29 December 2019

Dear Mr. Denton

Planning Application Ref: R/270/19/HH (resubmission of R/197/18/HH)
1 Pigeonhouse Lane, Rustington

Drawing Title: PROPOSED ELEVATIONS

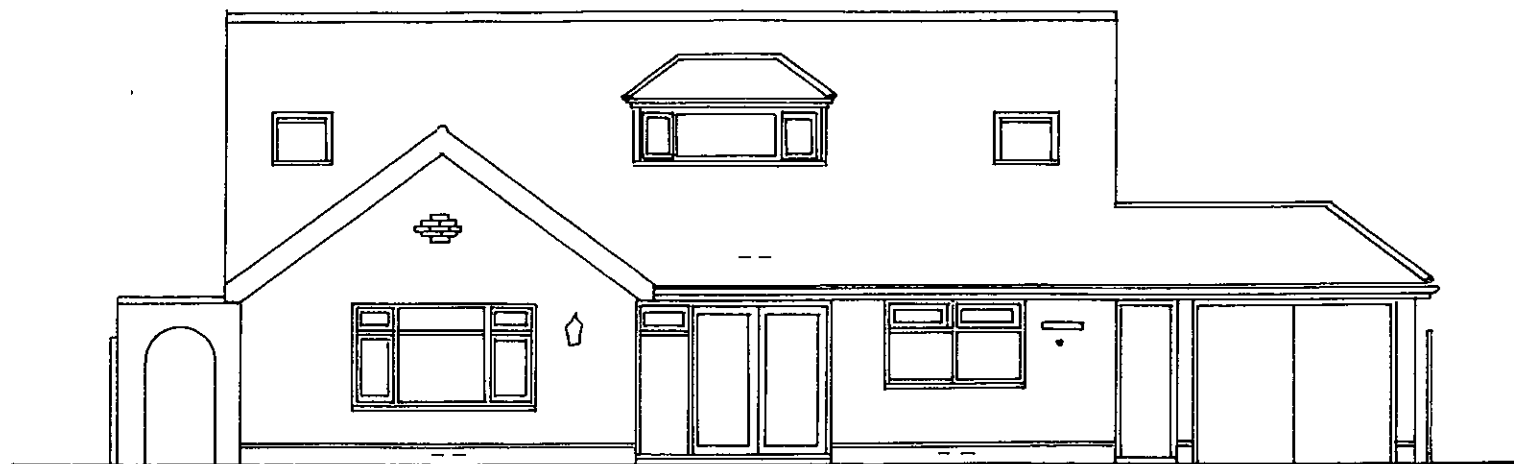
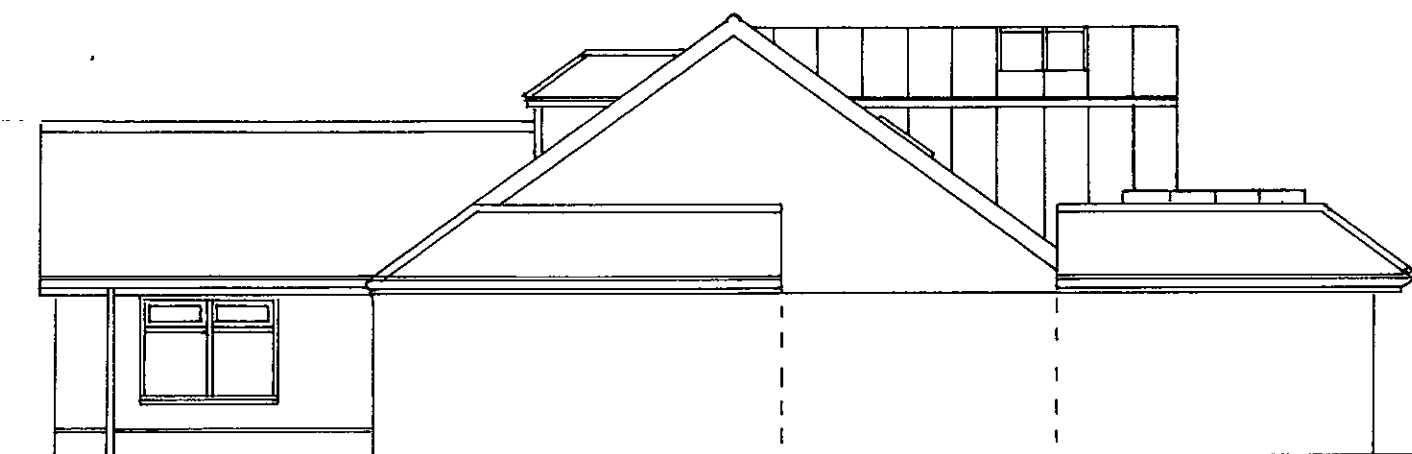
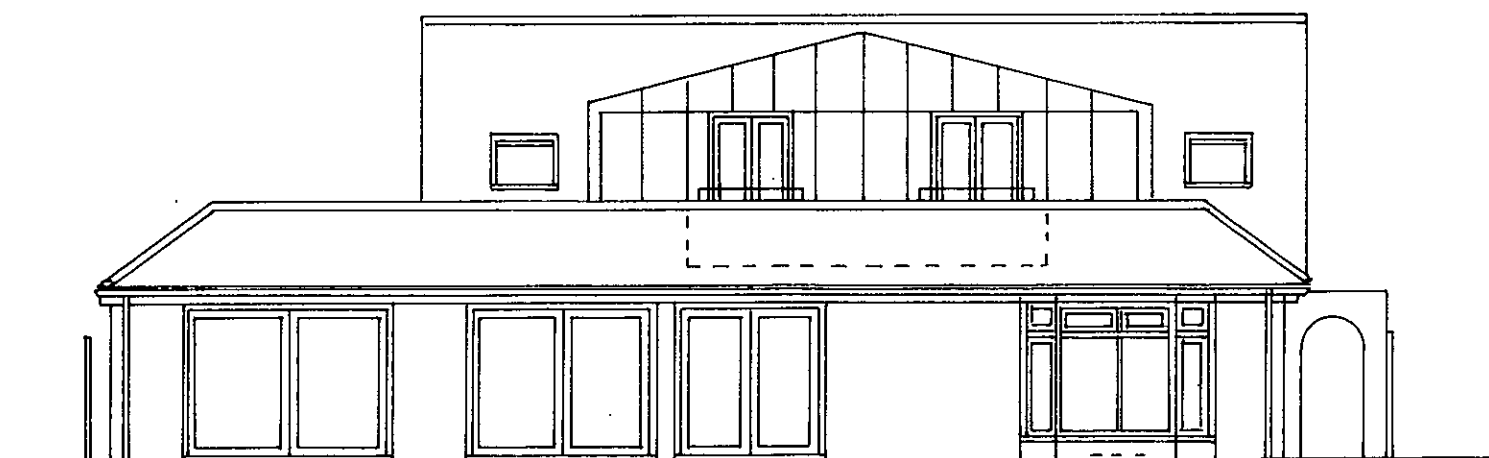
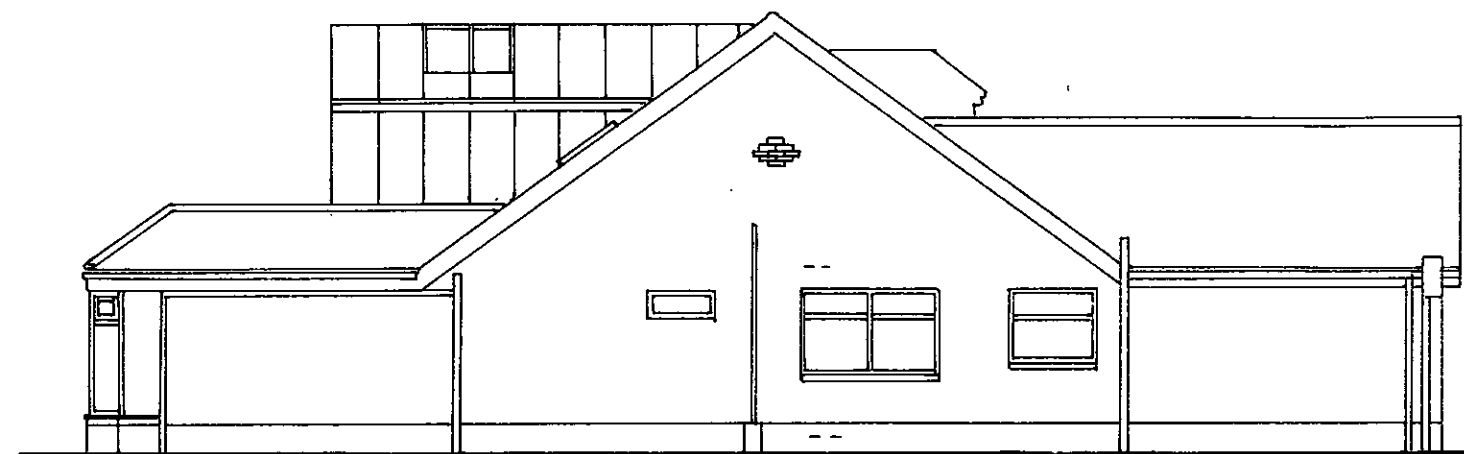
First Floor Rear Extension - Impact on Daylight: The proposals in the new application have been designed to reduce in part the issues of scale and massing in the previous rejected application. However, while the depth of the first floor rear extension has been reduced, its height and width as well as its close proximity to our boundary remain virtually unchanged. The rear extension also continues to extend past the line of the original dwelling, extending some 2.25 metres over the already extended footprint of 1PL. The proposals will continue to create very significant overshadowing and overhanging issues for our property, in particular in the living room, and will significantly restrict natural light especially during the winter months.

First Floor Rear Extension - Impact on Privacy and Amenity: The proposal to move the existing northern velux window on the east side of 1PL 1.3m closer to our property will afford it direct views into our living room and the kitchen/breakfast room beyond through the high level living room window. This will be even more pronounced if the velux (like the existing velux) is at the level proposed, a top-hung style with the sill around waist level, fully openable and the glass not opaqued. The same direct overlook will also be possible with a side view from the new proposed Juliet balconies with full opening doors affording views to north and south. Mr. Antoniou's assertion in the Planning, Design and Access Statement (clause 6.14) that: "There would be no loss of privacy with the new first floor windows extending views along the length of the garden as opposed to having views to the north and south" is frankly nonsense. This overlooking represents a very extensive intrusion into our privacy inside our property and loss of our amenity. Furthermore, our main patio (to the east) which includes our only outdoor dining area and also our principal garden space would be entirely overlooked by the proposed Juliet balconies. Mr. Antoniou states in clause 6.14 that "the adjacent outdoor space is not solely relied upon for external enjoyment". We do not believe that it is Mr. Antoniou's function to determine which part of our garden we may enjoy (and we believe the Planning Inspector concurred in his report (Clause 9)).

New Front Veluxes - Impact on Privacy and Amenity: The current proposal also includes a new velux window to the north west of the property which directly overlooks the sun patio adjacent to our living room. The new velux window is again only some 0.7m from the edge of the roof which gives it direct views onto our sun patio and obliquely through the high level window to our home office. Once again, this overlook will be even more intrusive

if the new velux is a top-hung style with the sill around waist level, fully openable and the glass not opaqued. Our patios, which are currently private and not overlooked, would therefore now both be fully overlooked and we would thereby suffer a loss of privacy and amenity which would greatly reduce the ability quietly to enjoy our outdoor space.

Grey Zinc Roof - Architectural Visualisation: We note that the proposals include a "grey zinc roof" for the first floor rear extension. We believe this is not vernacular to the area and it is difficult to visualise the intended result from the plans provided. We would therefore request an architectural visualisation to allow us to assess the materials proposed, their visual impact and whether they represent an addition which is subservient and not incongruous to the host dwelling.
